From: Tom Errico <thomas.errico@tylin.com>
To: Jean Fraser <JF@portlandmaine.gov>
CC: David Margolis-Pineo <DMP@portlandmaine.gov>, Katherine Earley <KAS@port...>
Date: 6/26/2015 10:38 AM
Subject: Jewish Community Center - Final Traffic Comments

Jean - I have reviewed the revised application materials and the following represents a status update on my previous comments.

SITE PLAN

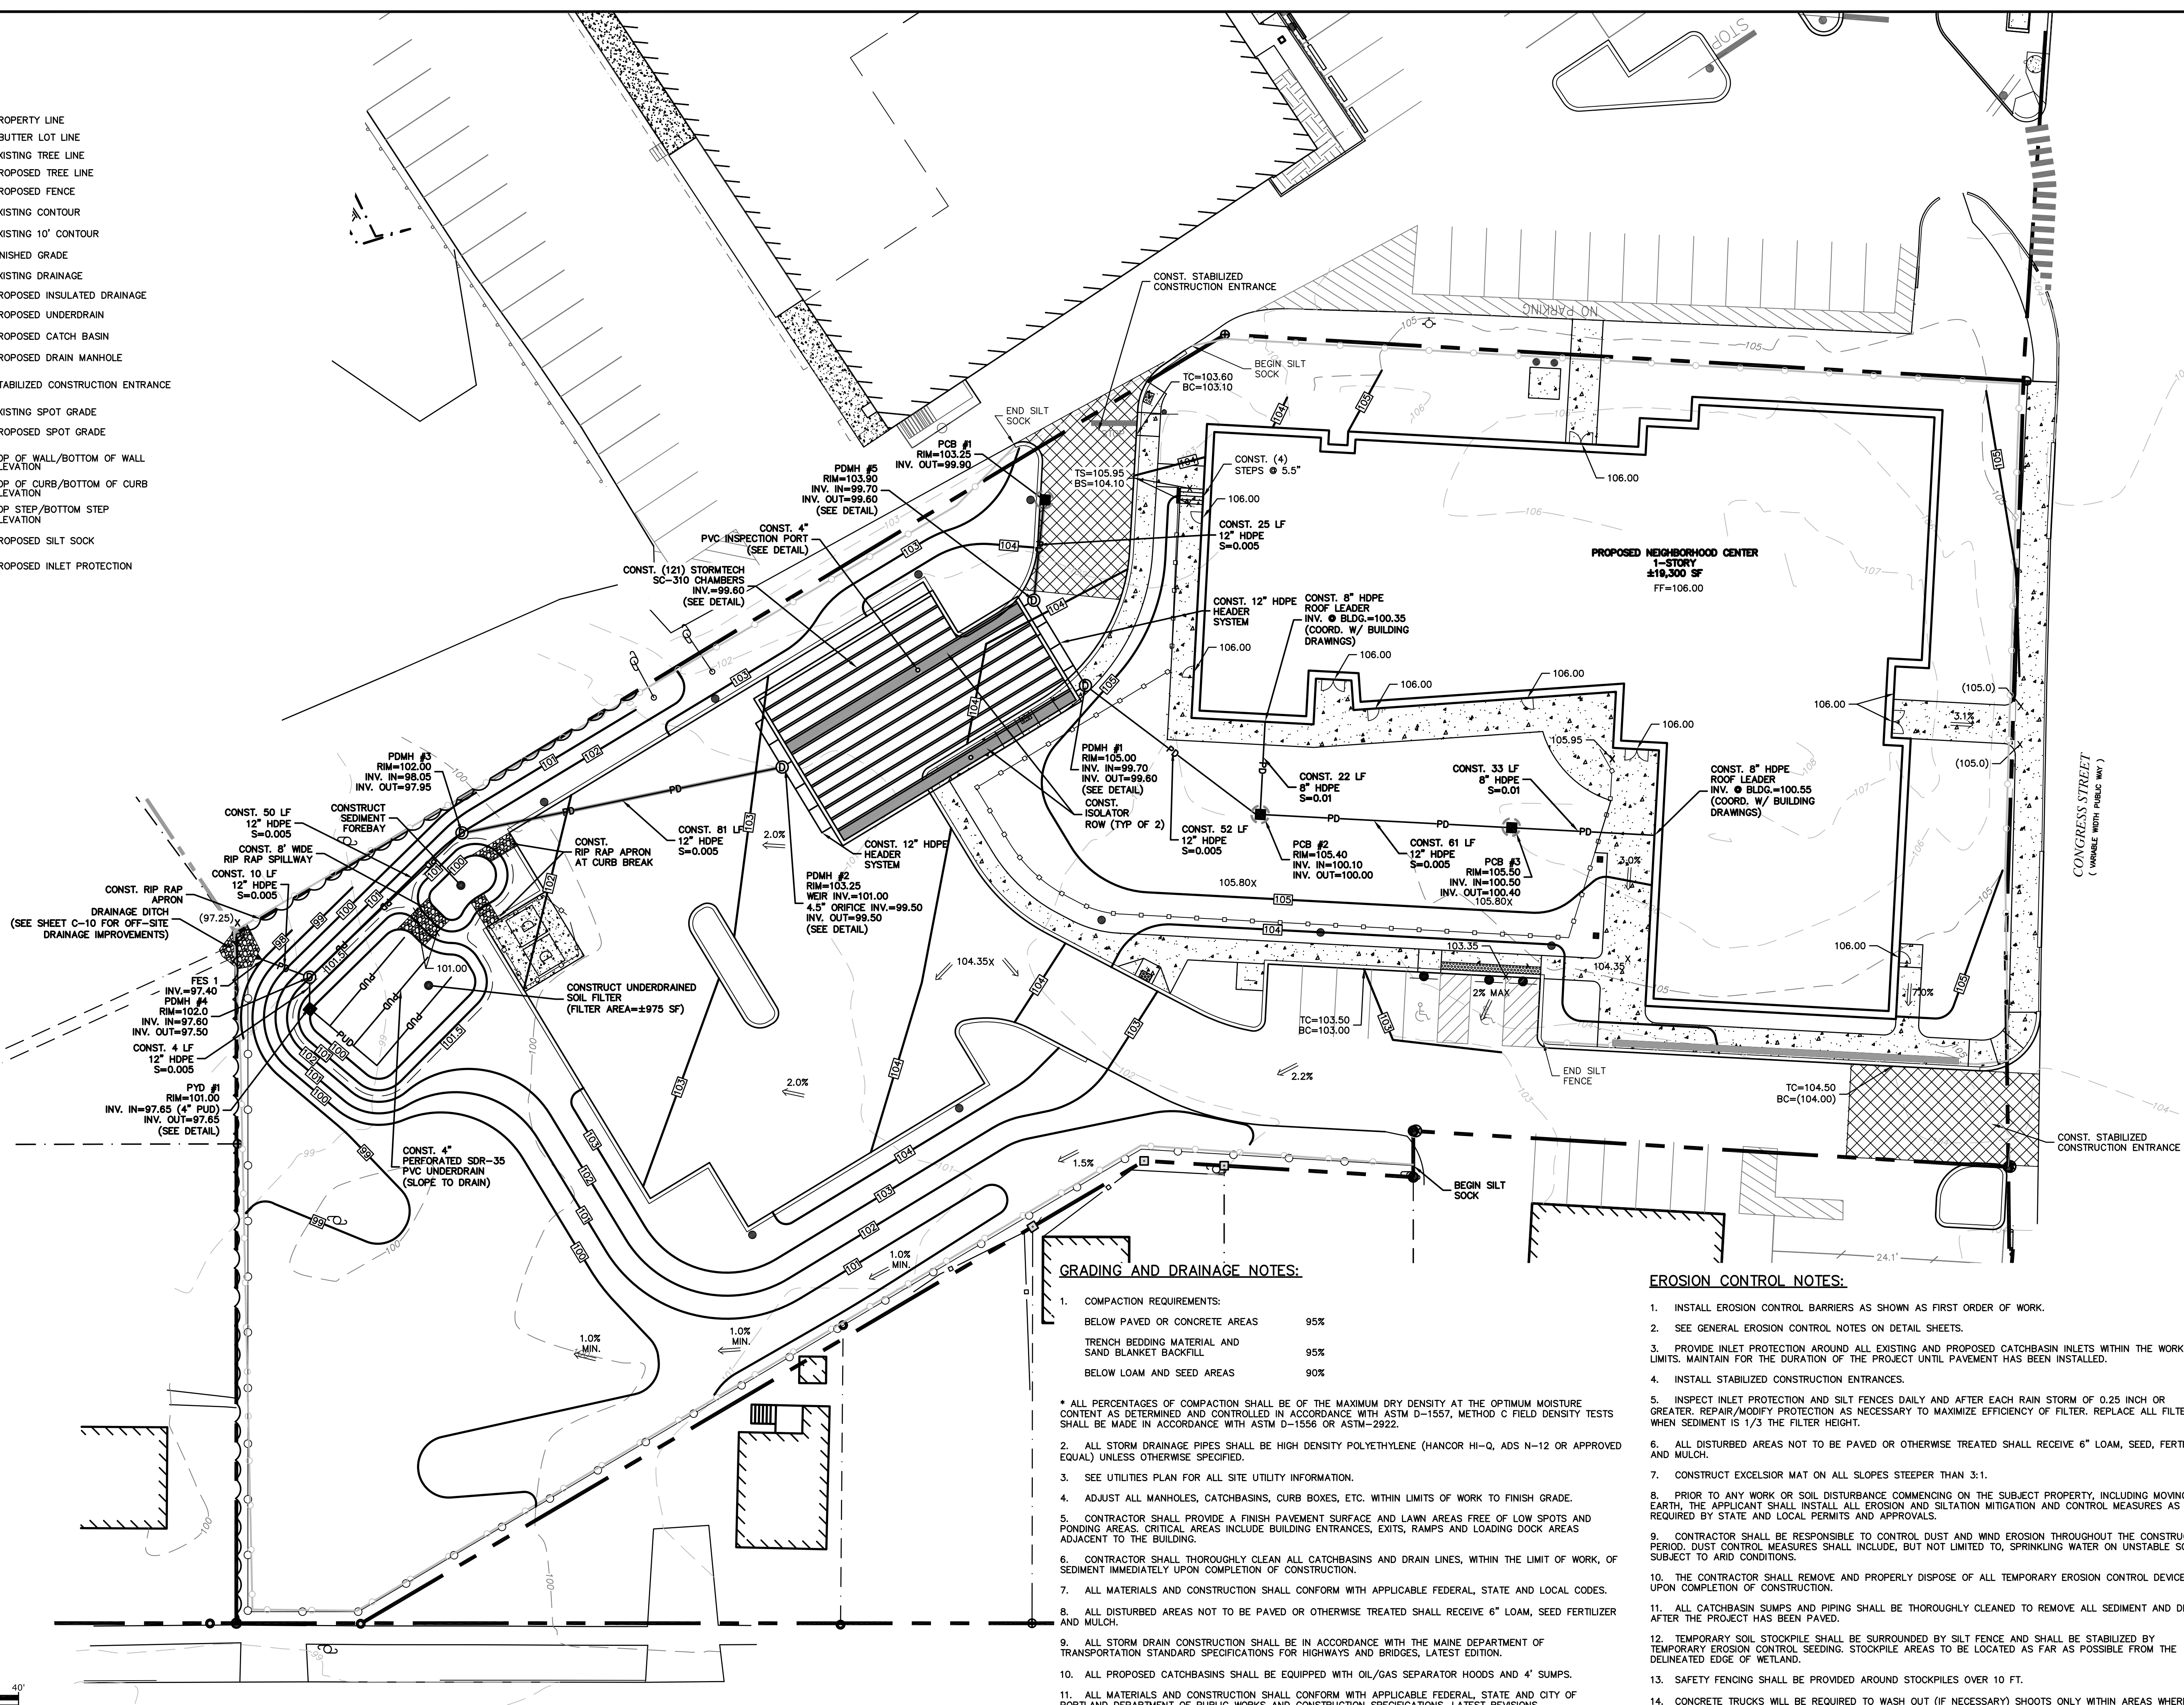
* The driveway entering the site from Congress Street is noted as having a width of 22.7 feet. This width (in the area where parking maneuvers occur) does not meet City standards and thus a formal waiver should be requested by the applicant.

* I would suggest a tip-down curb entering the driveway on Congress Street, as currently provided.

Status: The curb ramp layout should be revised so that the ramp flare does not impact accessibility along the sidewalk route. Having a tip-down design will help to address this issue.

* The applicant shall consider the formal delineation of the driveway along the medical office property boundary, when entering from Congress Street.

* The pick-up and drop-off of daycare and others will need to be carefully managed. Accordingly, the applicant should provide specific details on how this process will take place. This should include what building entrances will be used, sidewalk facilities between parking spaces and the noted entrance, etc. I would note that the pick-up/drop-off program must be managed such that vehicles are not parking along the driveway off Congress Street.

Status: I find the proposed driveway width to be acceptable given that most vehicles will be passenger cars and that a secondary driveway via the Westgate Shopping Center will be provided. I support this waiver request.

Status: The site plan has been revised and I find conditions to be acceptable.

Status: I have reviewed existing JCA activity at their current Portland site and I have recommended that a barrier be constructed that prevents pedestrians from accessing the building entrance near Congress Street. The applicant has revised the site plan to include a 18" sitting wall along the curb. While the height of the wall is mountable by pedestrians, I do believe the physical presence of the wall will deter drop-off and pick-up activity near Congress Street. Accordingly, I find conditions to be acceptable.
